From: Amanda Scholes on behalf of Planning.Responses
Sent: 10 October 2017 08:32
To: Planning Scanning
Subject: FW: LU/278/17/RES North Littlehampton Strategic Development Site. Land West of Toddington Park, Toddington Lane , Littlehampton BN17 7PP
Attachments: ARU 17 32A - North Littlehampton Strategic Developement Site.pdf

Our Ref: NW/ARU/17/32A

Re: North Littlehampton Strategic Development site, Land West of Toddington Park, Toddington Lane , Littlehampton

Thank you for your correspondence of 11th September 2017, advising me of an Approval of Reserved Matters following Outline Permission LU/47/11 for Construction of the southern section of the Lyminster Bypass, including northern and southern roundabouts, surface water drainage and landscaping. Departure from the Development Plan & affects a Public Right of Way.BN17, for which you seek advice from a crime prevention viewpoint.

LYMINSTER BYPASS - SOUTH
NORTH LITTLEHAMPTON
RECO WALLS (WSSC REF: 6078 & 6079)
GENERAL ARRANGEMENT

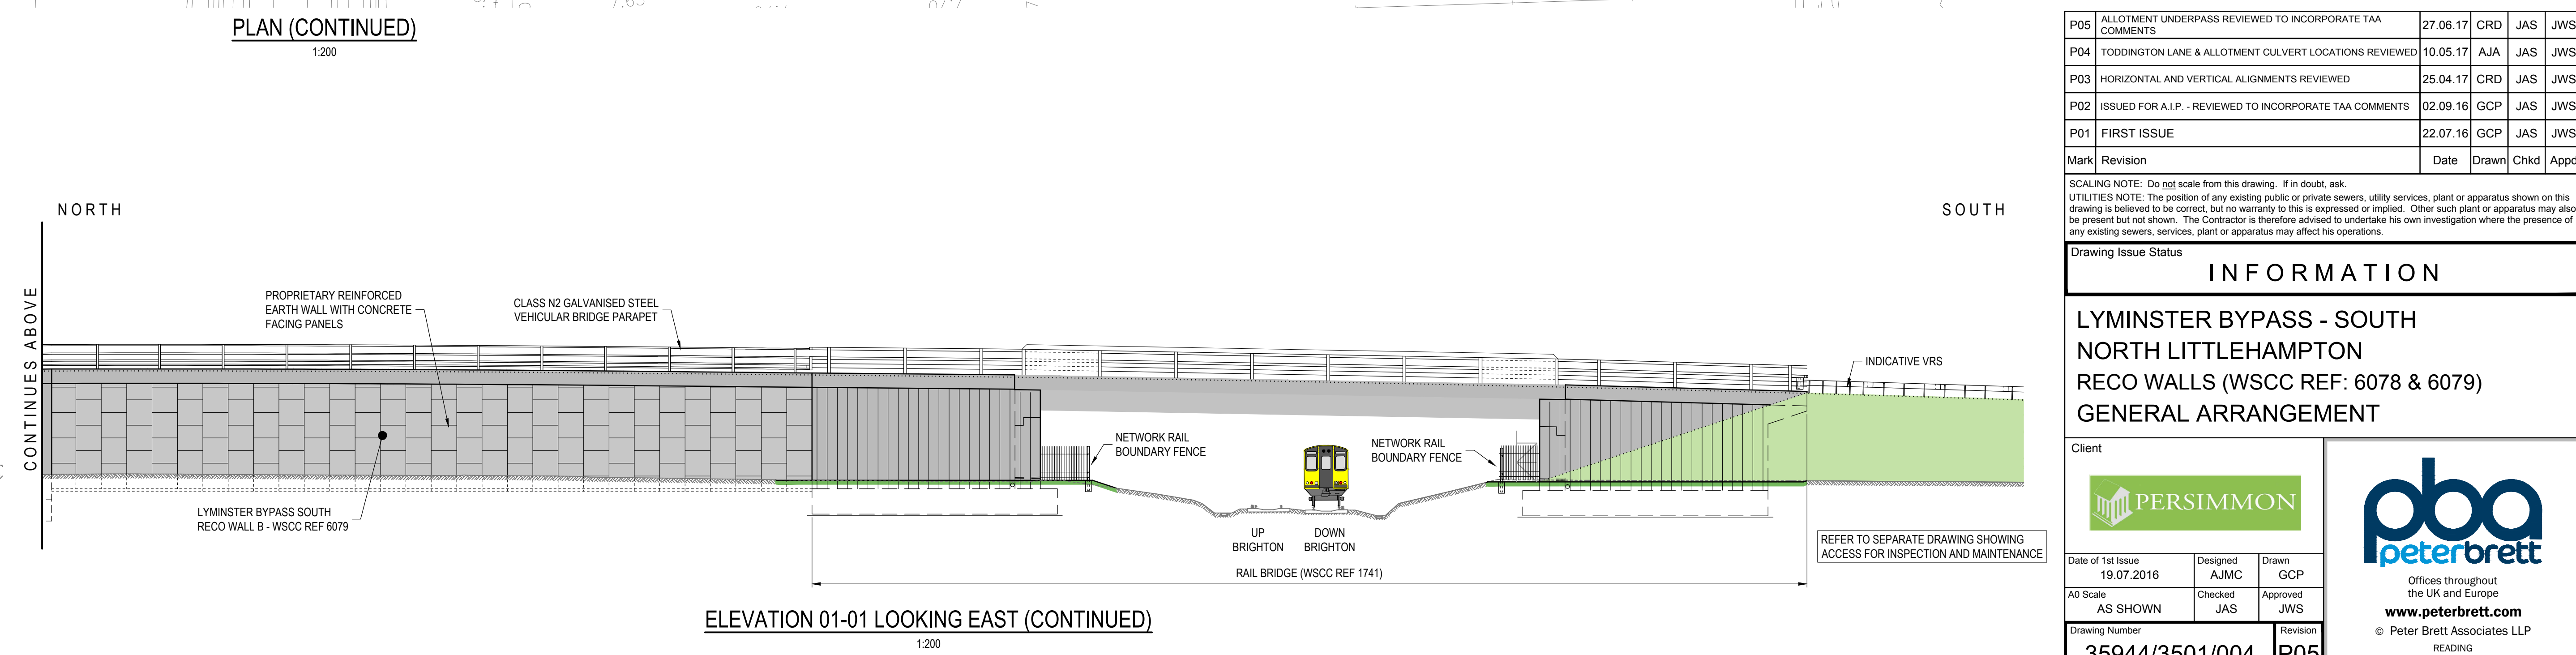
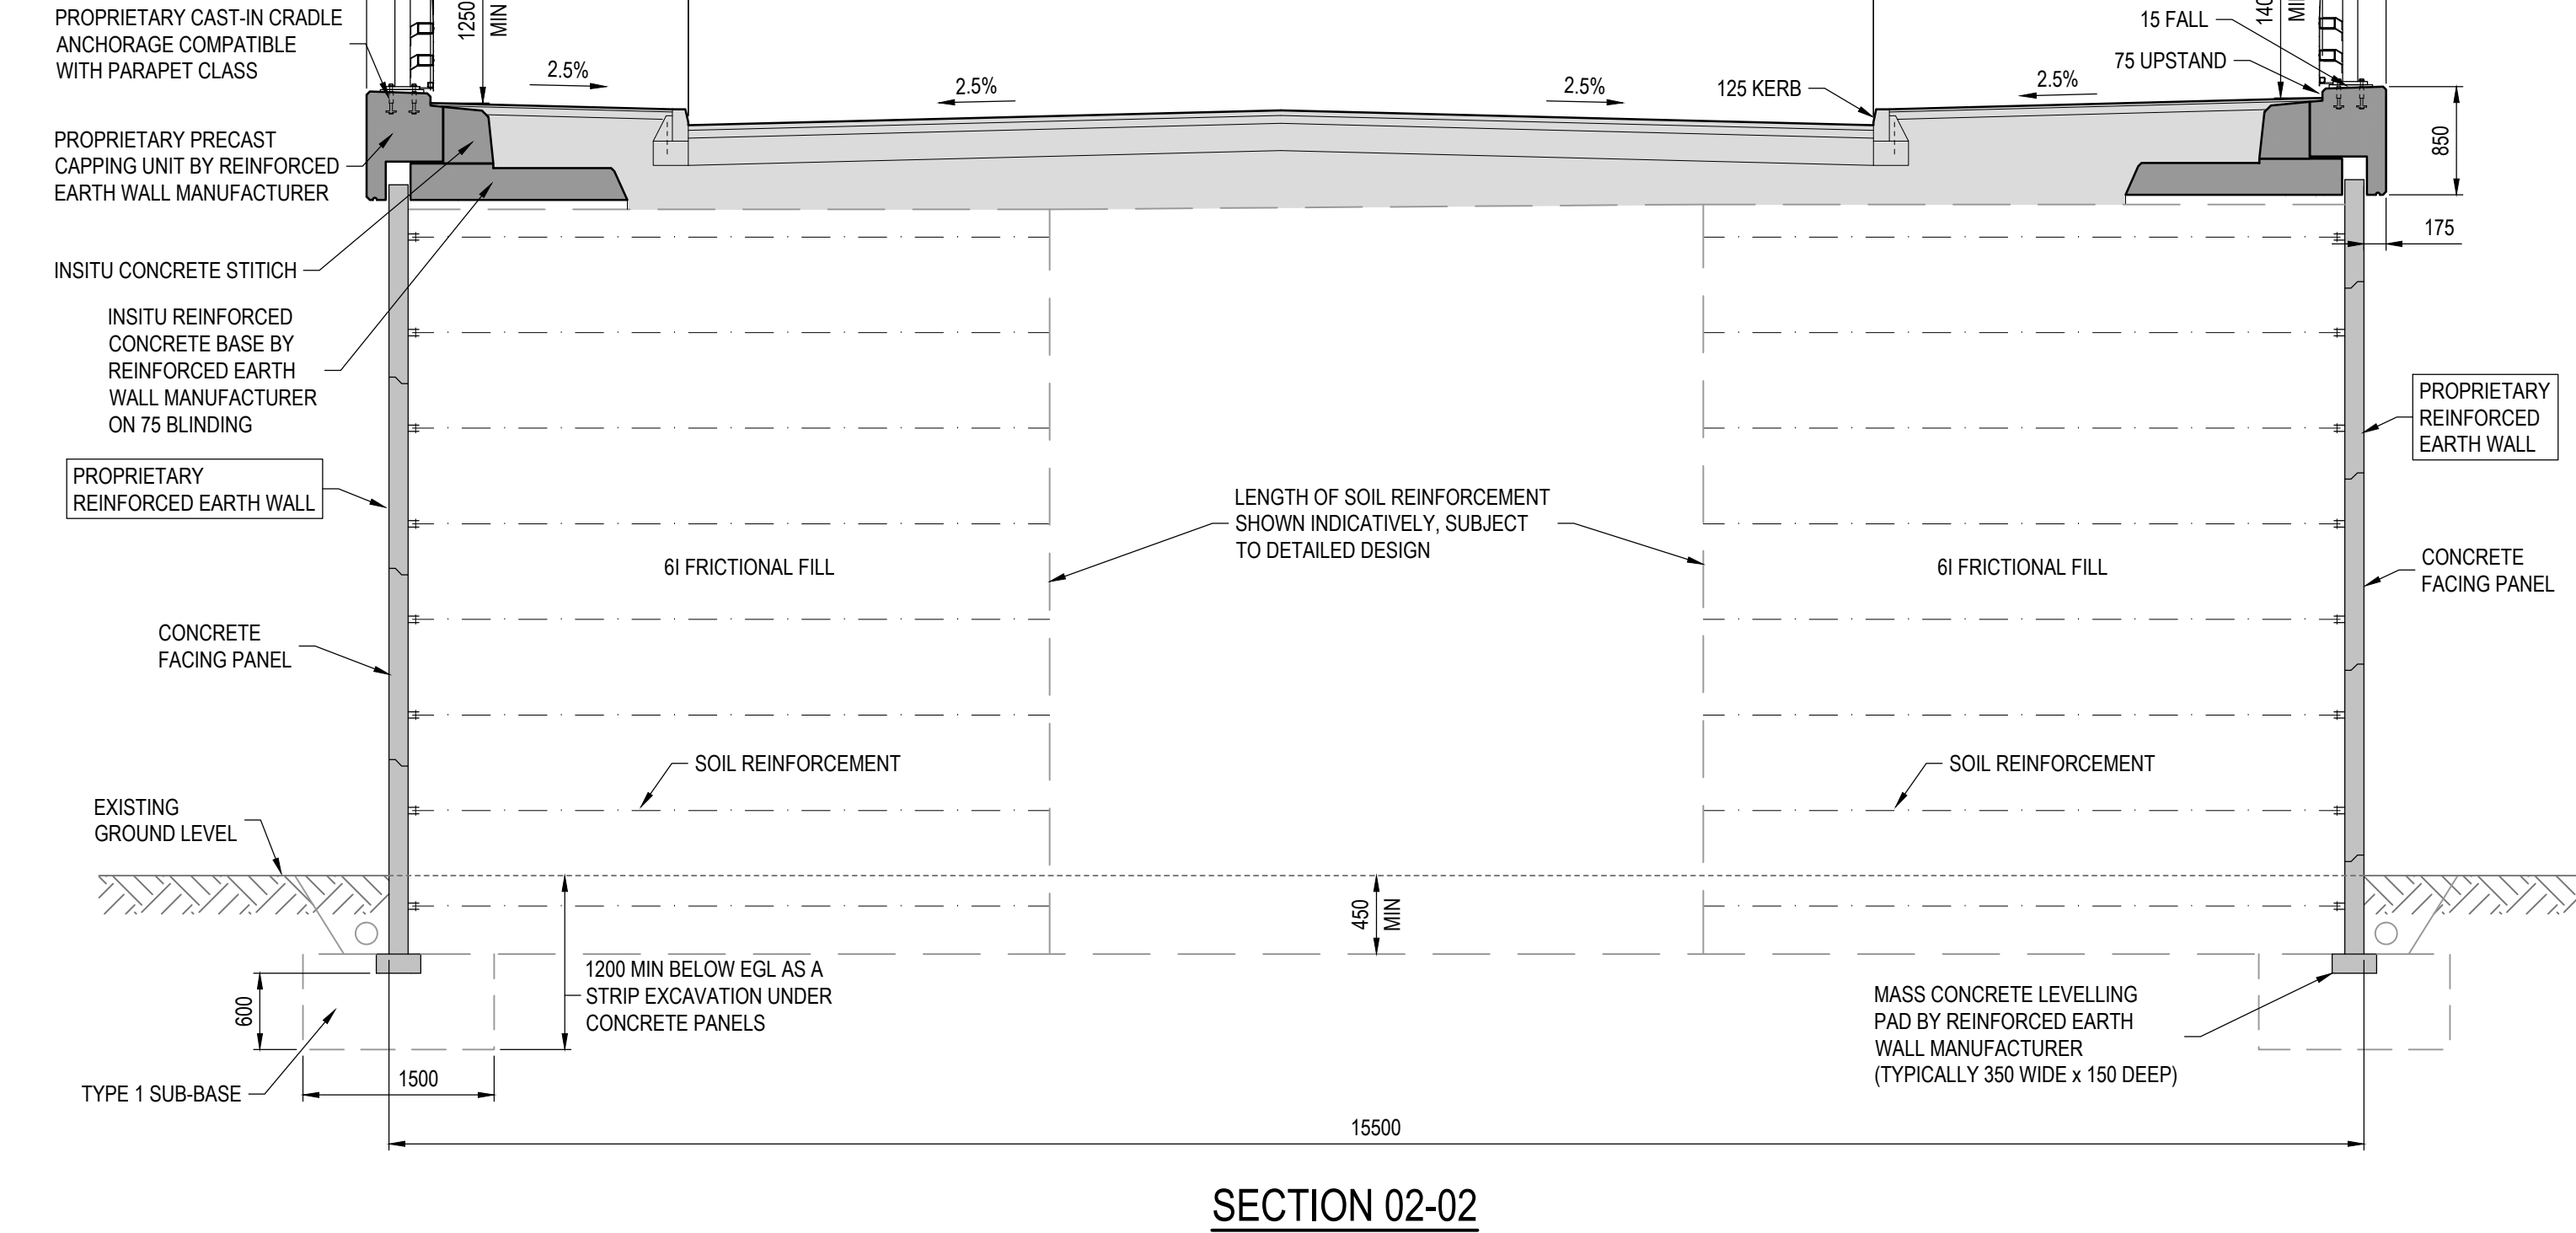
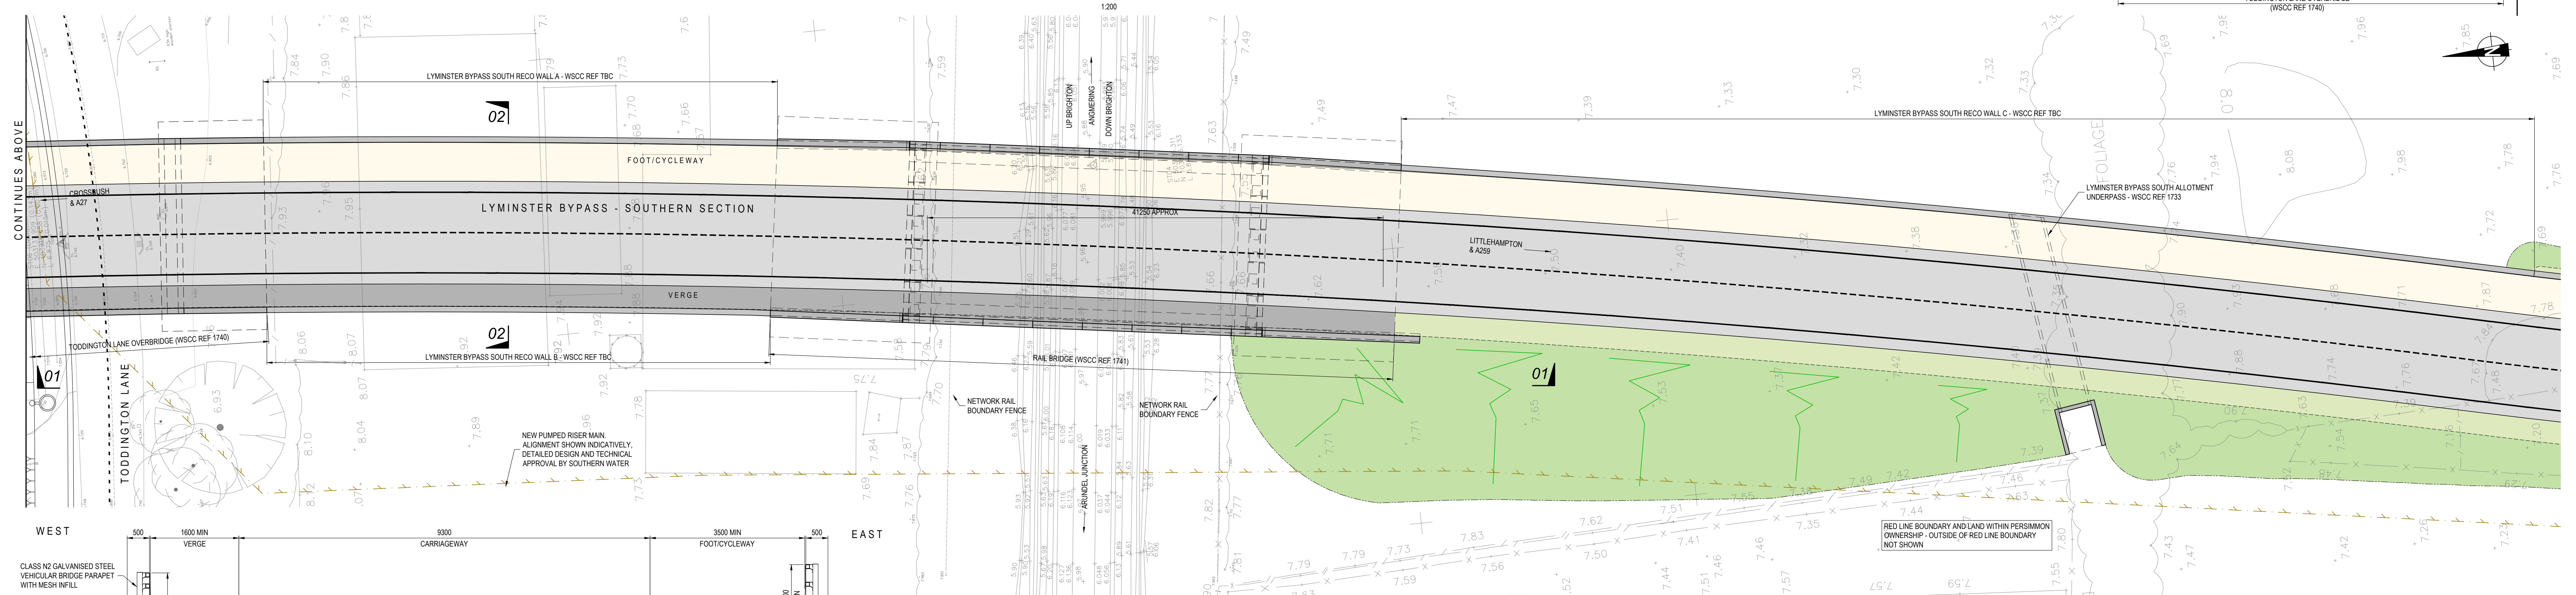
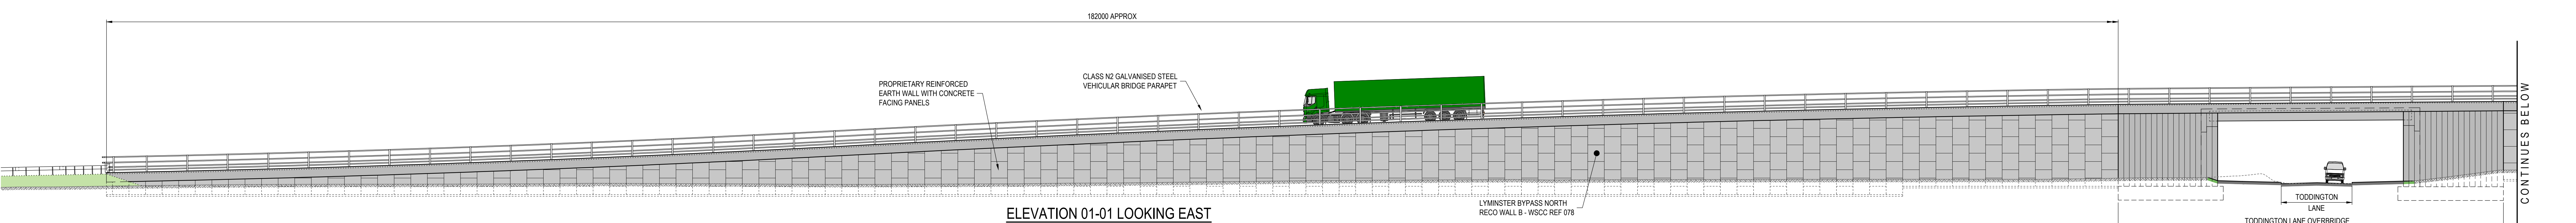
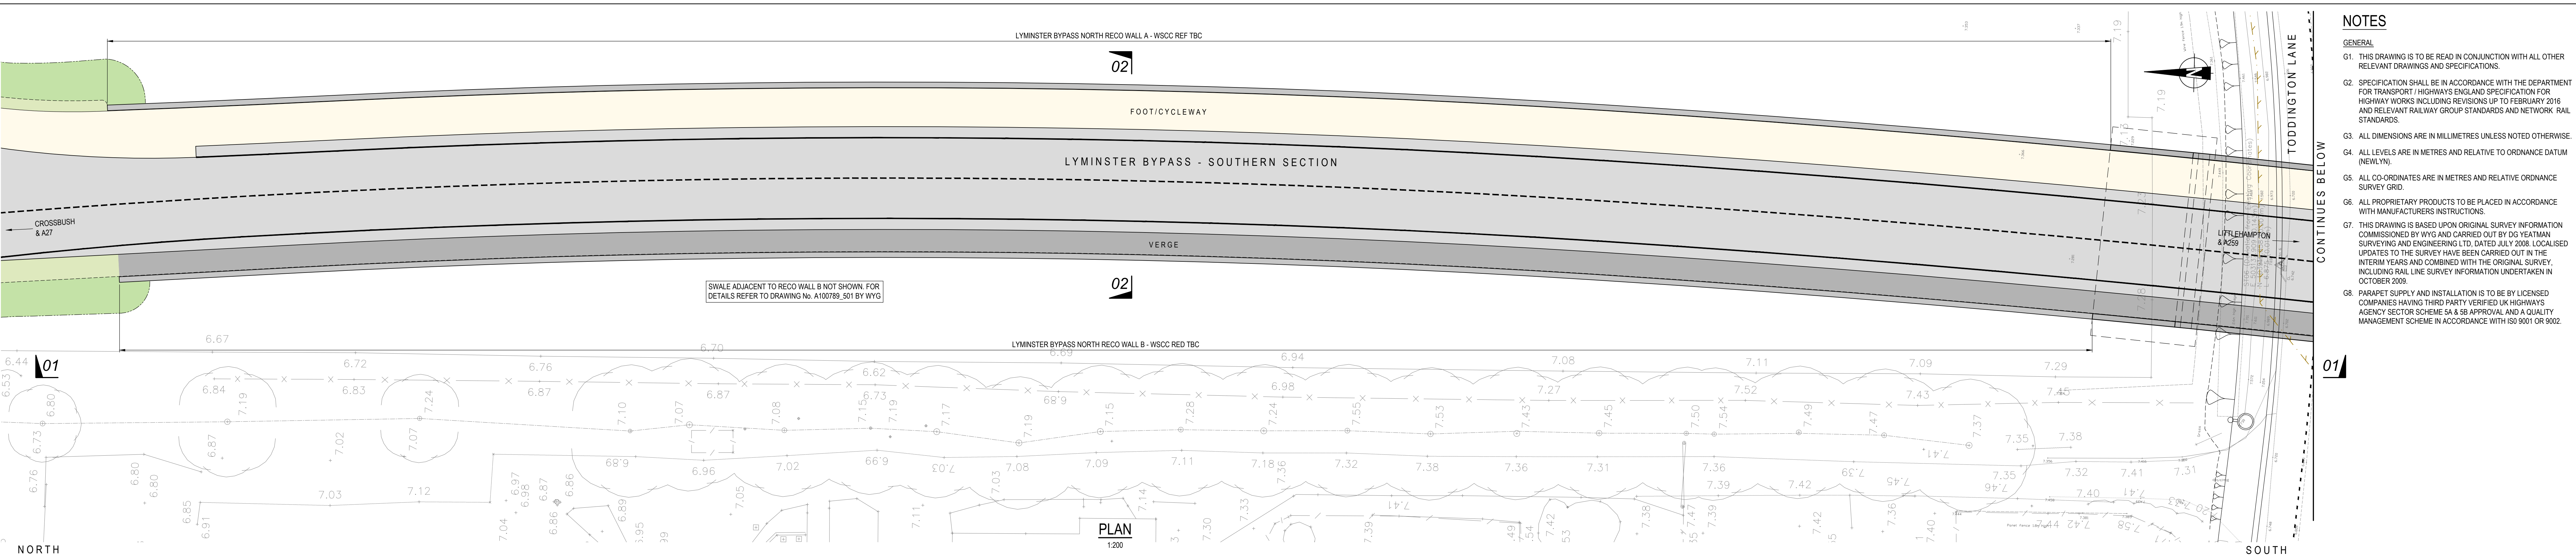
The pedestrian under pass beneath the Lyminster by Pass (north of the railway bridge), leading to the allotments is an area of concern, in that it may attract such behaviour depending on its accessibility and frequency of use.

If access is only for allotment use, then I would recommend it is not lit, as it will be used main during day light hours and less likely to attract antisocial behaviour at night. However if it is regularly used by a variety of the public then I recommend that it is illuminated so give a clear view completely through its length at night.
